**Minto Resource Recovery Facility (SSD-5339)
Request for additional information**

I refer to the additional information dated 22 February 2022 for the Minto Resource Recovery Facility (SSD-5339). The Department has reviewed the information and notes there are still matters to be addressed.

DRAWING TITLE				
SWEPT PATH ANALYSIS - SHEET 2 TURNING MANOEUVRE ON SITE				
PROJECT NO.	PLANSET NO.	RELEASE NO.	DRAWING NO.	REVISION
P1203464	PS02	R15	PS02-DZ02	H

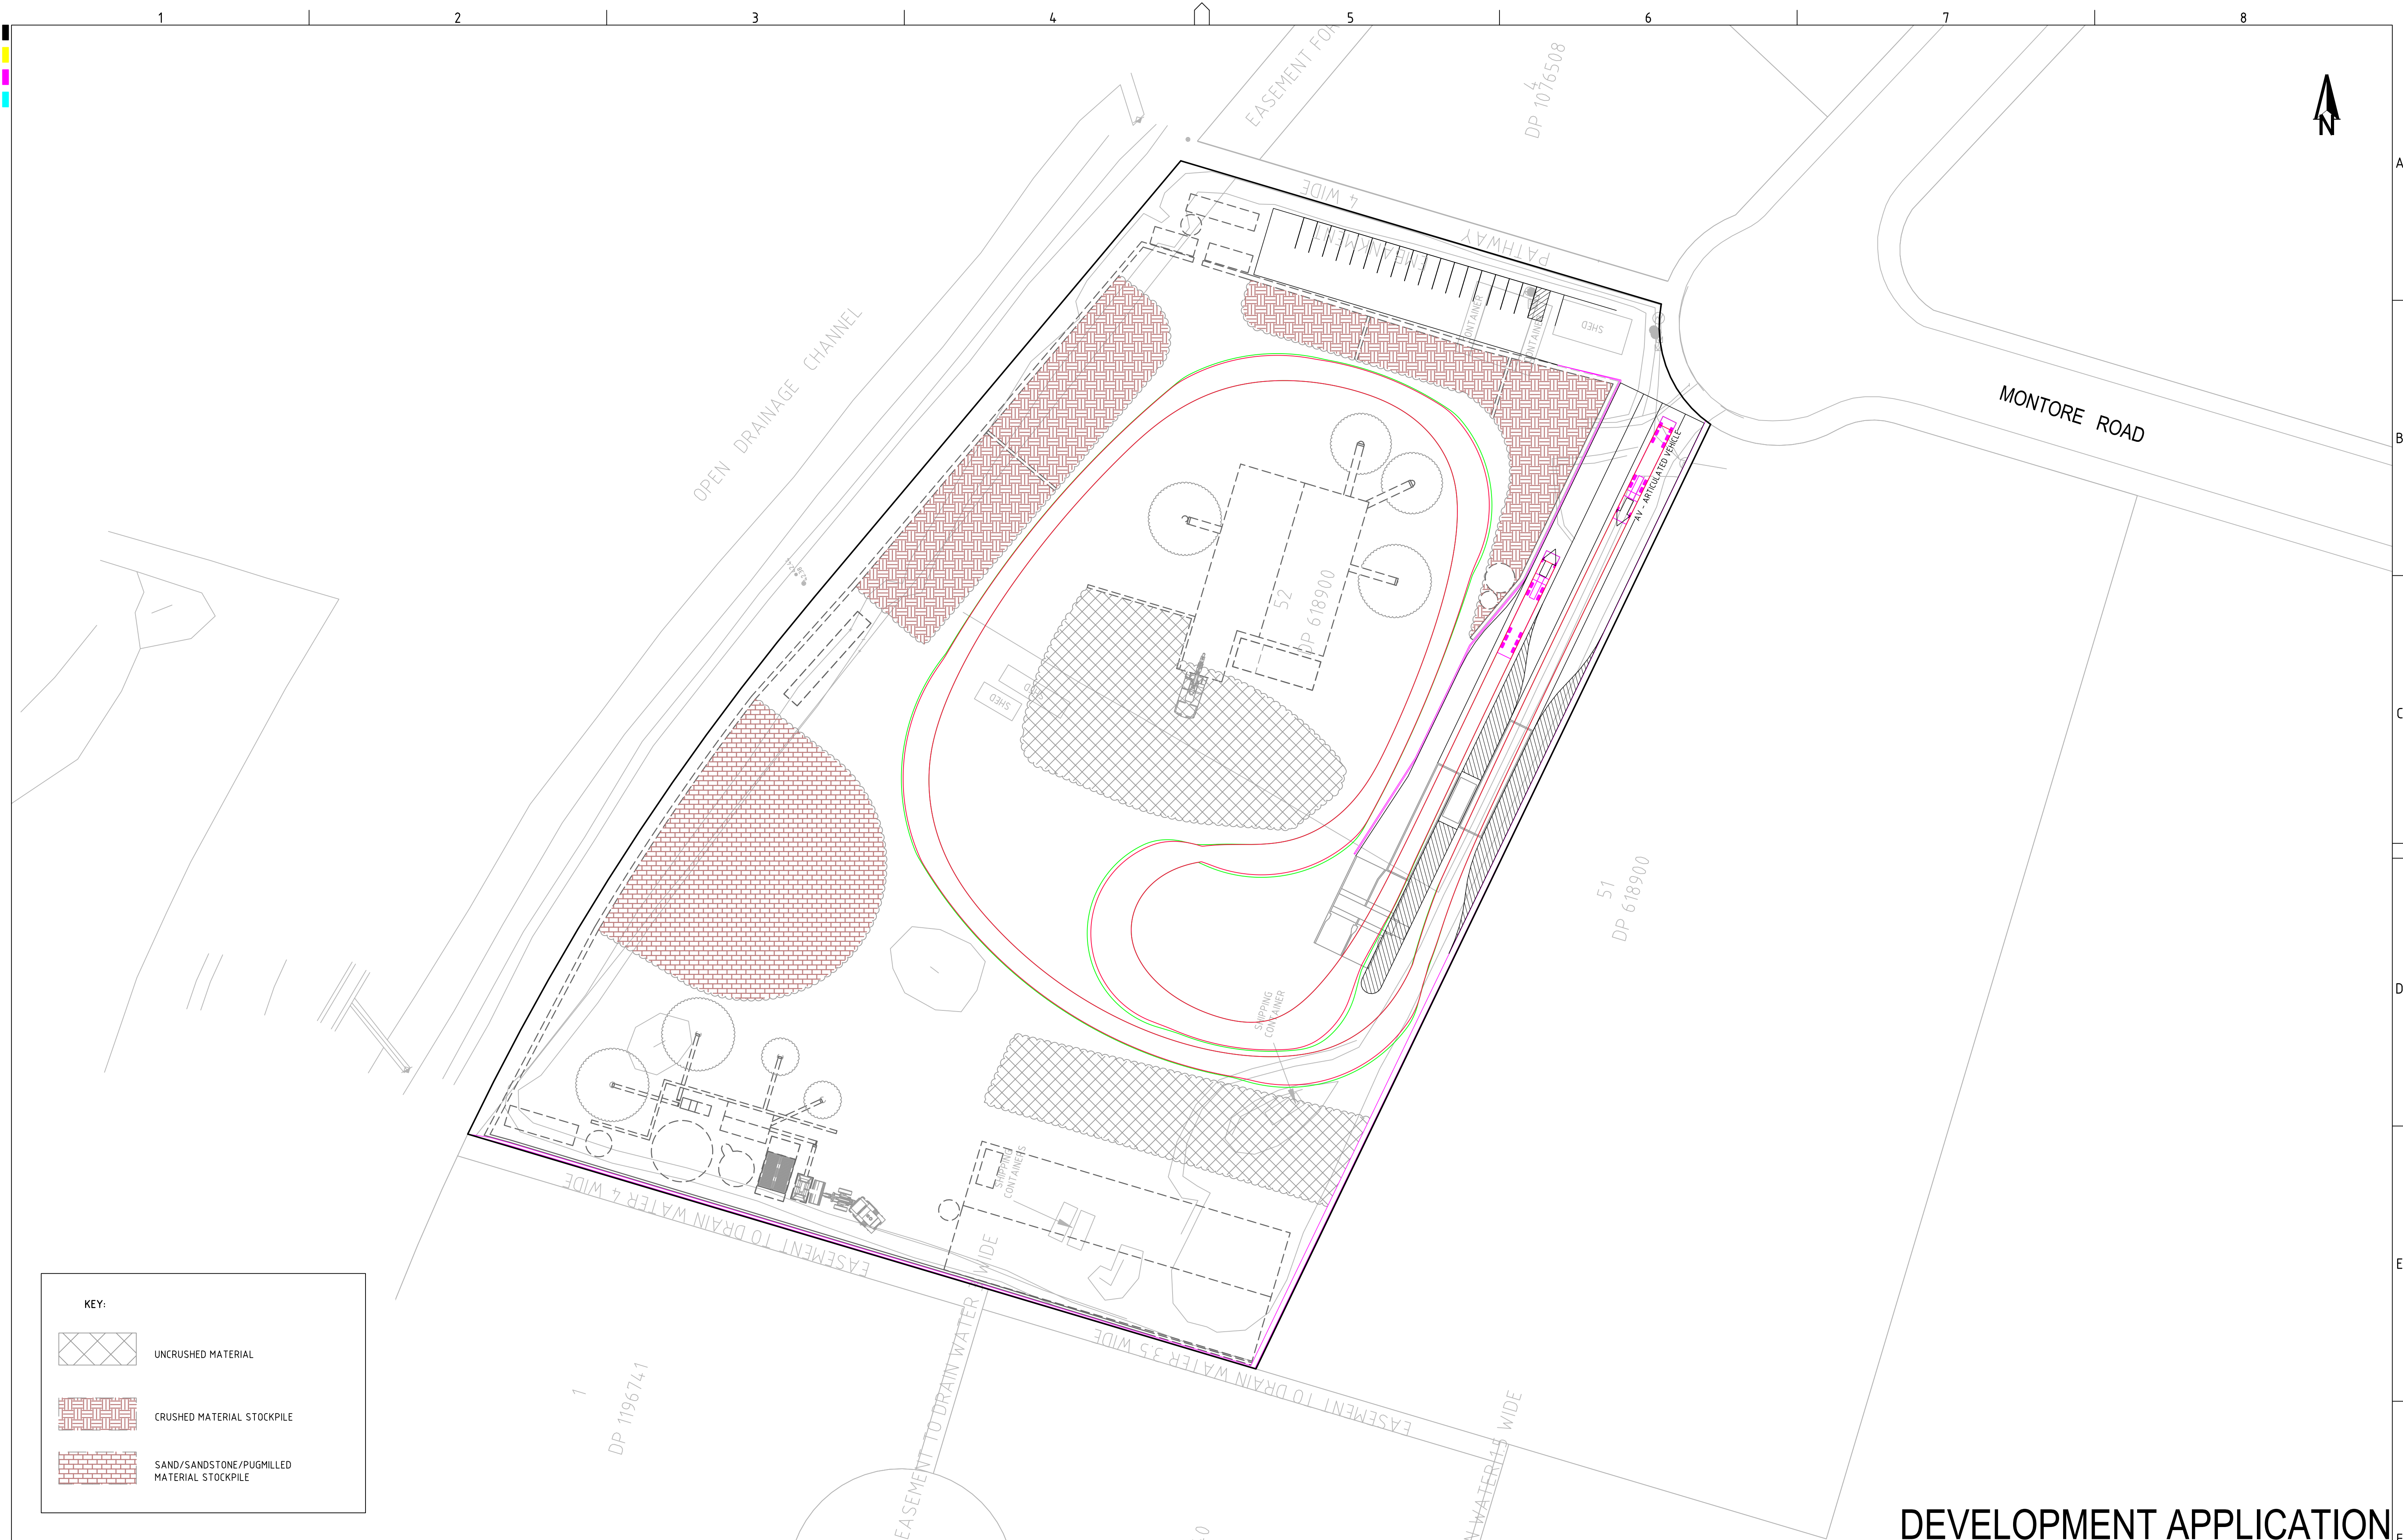
- The site appears constrained in regard to heavy vehicle manoeuvrability due to the proposed stockpile volumes. As such, please explain why the proposal would store more than 31 days-worth of waste onsite (50,000 tonnes) and 25 days-worth of product (25,000 tonnes) at any one time and consider reducing the size of stockpiles.
- Changes to the development made since exhibition of the EIS have still not been clearly articulated. Please list all changes made to the development, noting that a description of changes made to plans is not required. Changes should include the amendment to cut and fill and boundary fence, amendments to the stormwater system, additional length of noise wall, additional bunker walls etc.

- As previously discussed, please show the tip and spread areas and truck standing areas on the site plan, noting that recent correspondence with EPA also confirms its requirements for dedicated tip and spread areas. It is acknowledged these areas are not fixed and location is dependent on how much waste is stored in the stockpiles, however, please show the tip and spread areas when stockpiles are at their maximum capacity.
- Please update the swept path diagrams for both circulating and turning trucks to include the tip and spread and truck standing areas above.
- Please provide a swept path analysis of the design heavy vehicle accessing and loading from stockpile C.
- Describe where inspection point 1 (required by the Standards for Managing Construction Waste) would be located.
